**ADDENDUM TO THE
FINAL DRAINAGE REPORT
FOR
HOMESTEAD AT STERLING RANCH FILING NO. 2**

EPCD File No. SF-19-004 /CDR-20-012

**August 18, 2020
Project No. 25188.00**

Engineering Review

PROPOSED DRAINAGE MAP (ADDENDUM)  
 HOMESTEAD AT STERLING RANCH FILING NO. 2  
 JOB NO. 25188.00  
 03/23/2021  
 SHEET 1 OF 1

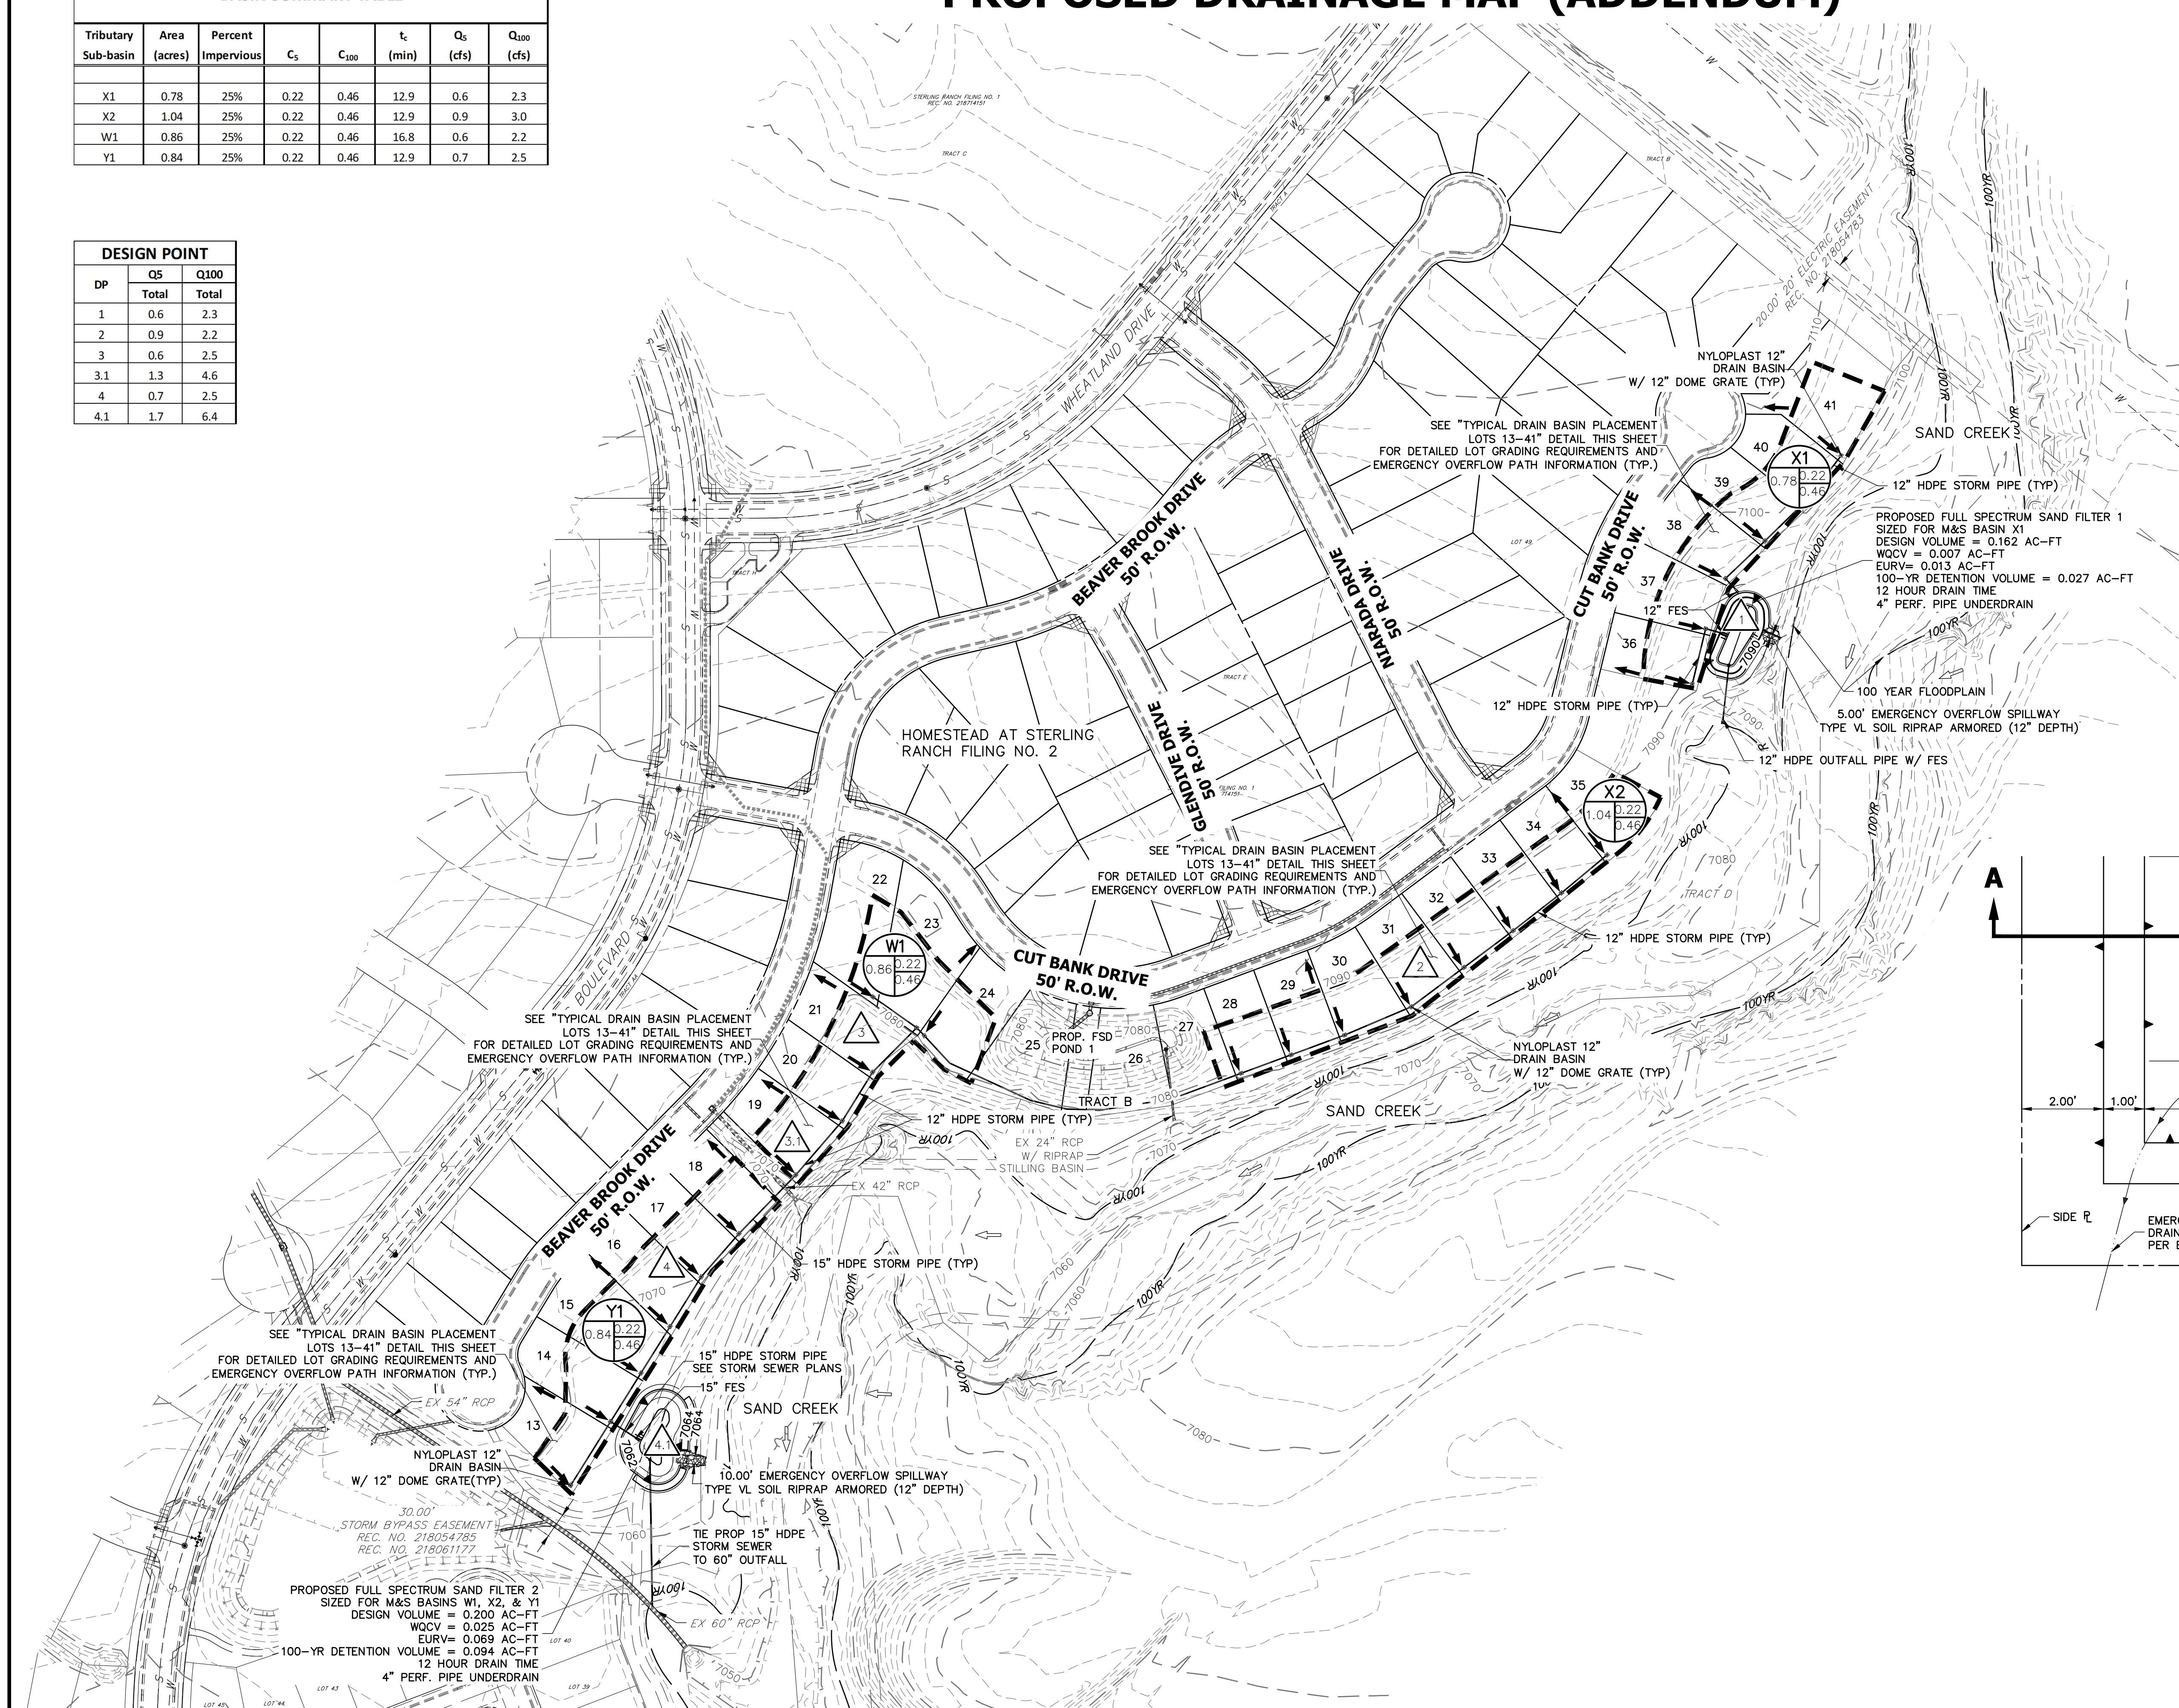
Are these needed or would a swale with rundown work in this sub-basin?
